RE: ENFIELD INTERMODAL LOGISTICS CENTRE MODIFICATION REQUEST NO.6

Strathfield Council welcomes the invitation to provide comments regarding the public exhibition of Modification Request No.6 (MP 05_0147 MOD6) for the Intermodal Logistics Centre at Enfield.

Enfield Intermodal Logistics Centre, Modification Request (MP 05_0147 MOD 6)

DRAFTED BY: JT, AK	DATE: 05/03/2012	PLAN SCALE: AS SHOWN SCALE BAR
PROJECT CODE: ILC-E-G-MOD 6 SITE LAYOUT	DWG NO: SEDP181A

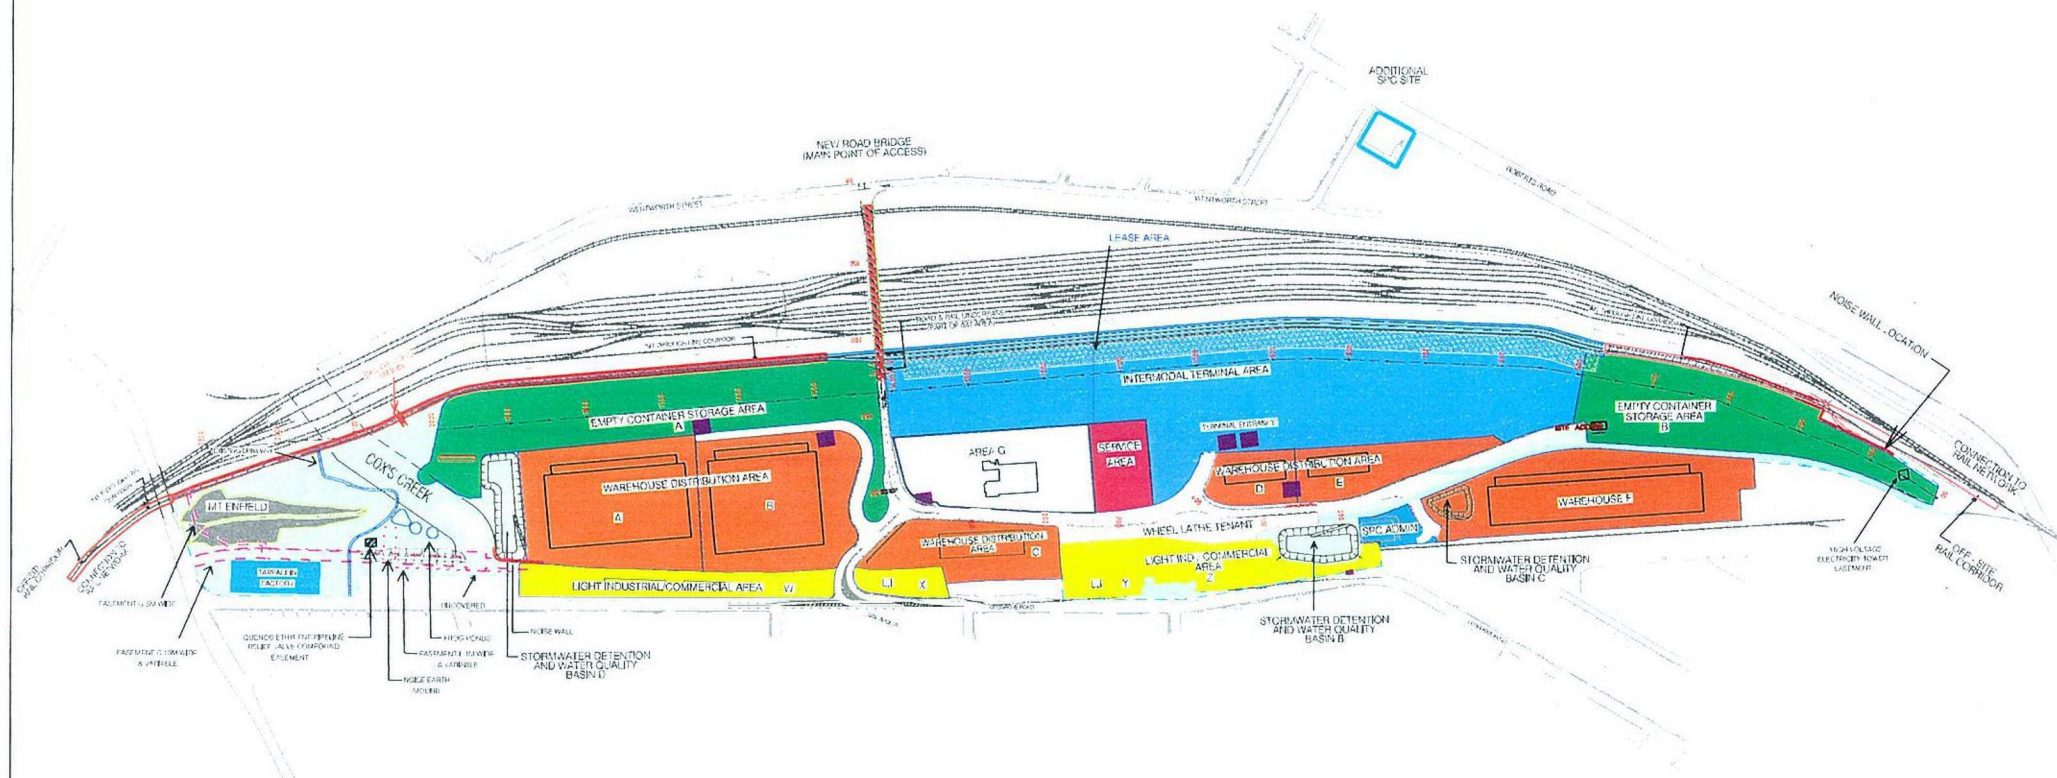
1. The Revised Site Layout (refer Attachment 5) for Modification Request No 6 does not indicate or label the 'Community and Ecological Area'. Council requests that the Site Layout Plan be amended to be consistent with the original 5/9/07 project approval for Enfield ILC ie. the precinct south of Coxs Creek including Mt Enfield, Tarpaulin Factory, Frog Ponds should all be labelled 'Community and Ecological Area' and coloured accordingly eg. light green.

2. Since the original approved Site Layout Plan, the amount of landscaped areas (not including 'Community and Ecological Area') along Cosgrove Road has gradually been reduced to the detriment of the sites landscape aesthetics, biodiversity opportunities and screening of the site from surrounding areas. This is particularly impacts the Cosgrove Road frontage of the site.

The general landscape area (not including the 'Community and Ecological Area') indicated in the Modification Request No 6 'Revised layout Plan' (refer attachment 5) clearly has been significantly reduced from the original approval and from previous modification requests. Council

requests that the further reductions in landscape area proposed in this modification request be refused and that opportunities to return the more consistent with the originally approved landscape areas be pursued.

3. ARTC Access Point - The fenced access track to the marshalling yards for rail maintenance 4m wide' (to north of Tarpaulin Factory) enters Cosgrove Road opposite residential properties. The truck movements generated by the planned ARTC rail line project will have detrimental impacts on the residential properties on the eastern side of Cosgrove Road. This impact would be reduced if the entry was located further north along Cosgrove Road. It is noted that Council did provide comment and issues for consideration (February 2010) in regard to the general concept of providing an access route for the ARTC, however this specific access point was not provided to Council to comment on.

Figure 5 – Revised Plan of Subdivision

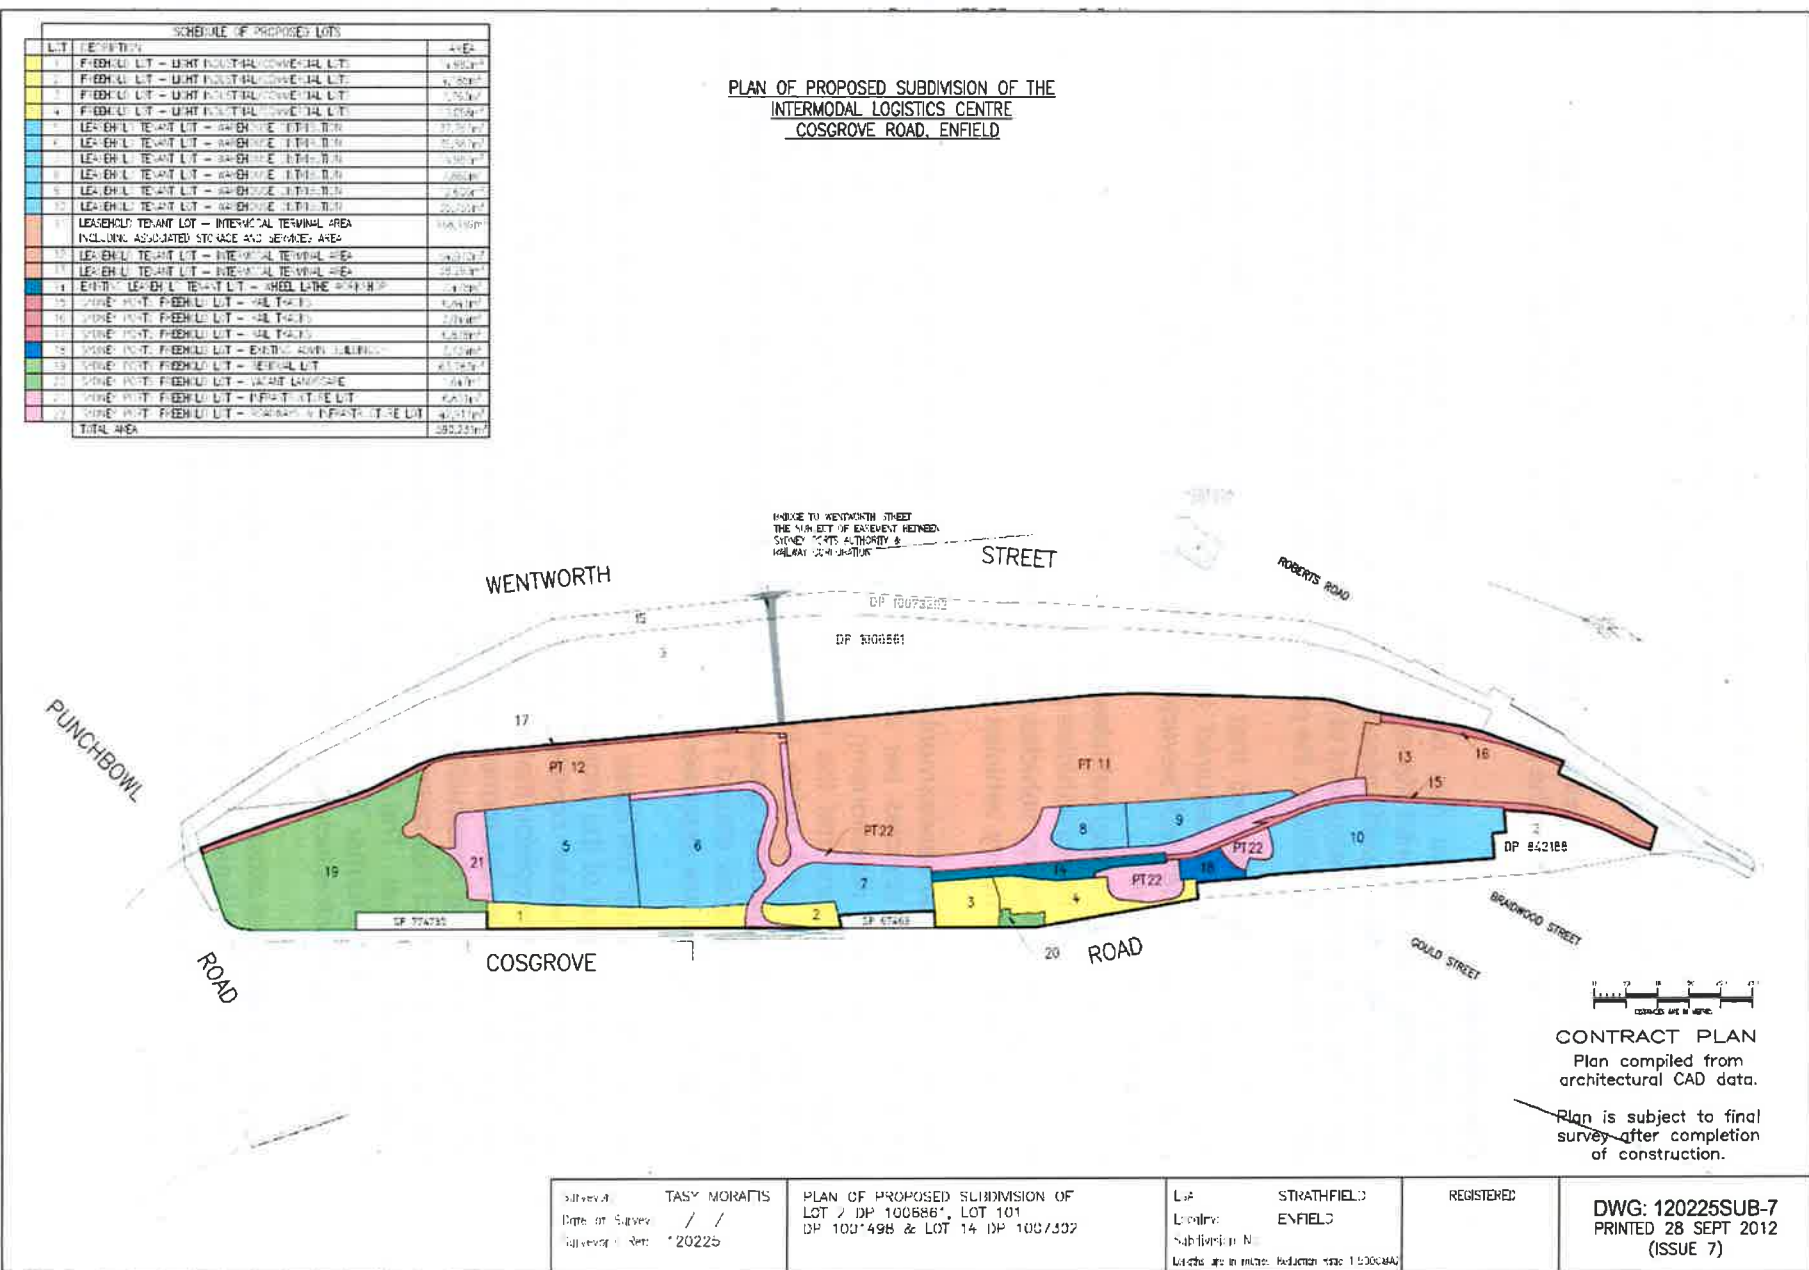
1. The proposed subdivision pattern (refer Attachment 6) conflicts with the intent of the original approval for the southern section of the site becoming a 'Community, Heritage and Ecological Area'. The subdivision plan proposes to subdivide the 'Ecological & Community and Heritage Area' into three lots being: Lots 19, 20 and 25. There is no advantage or logical justification provided in the modification request to divide up the 'Ecological & Community and Heritage Area' which is a key component of the original Project Approval. Subdividing Lot 19, 20 and 25 undermines the preservation of this area especially as it creates potential opportunity for the sale or leasing, particularly of Lot 19 which includes the area at the corner of Punchbowl Road and the Tarpaulin Factory.

The subdivision that creates Lots 19, 20 and 25 is a considerable change that is not supported by Council because it potentially diminishes the amount of land originally dedicated in the original approval for community, ecological and heritage purposes. This precinct should be protected by retaining the land to the southern side of Cocks Creek as one lot. Operational issues for this area such as controlled access to the frog habitat and to the steeper areas of Mt Enfield and whether the Tarpaulin Factory remains on site or is relocated, do not impact on preserving this whole area as a 'Ecological & Community and Heritage Area'.

2. The gradual reduction in the general landscape area across the Enfield ILC, particularly along the eastern side of the site facing Cosgrove Road as outlined above under the Site Layout Changes section is a serious concern. The subdivision of the sites to the eastern section of the site limits the areas dedicated to general landscaping to Lot 21 (other than the Community & Ecological Area south of Cocks Creek) which is not an acceptable amount. Therefore Council does not support the subdivision layout in the present form unless more areas are dedicated to general landscape area to be more consistent with the original approval.
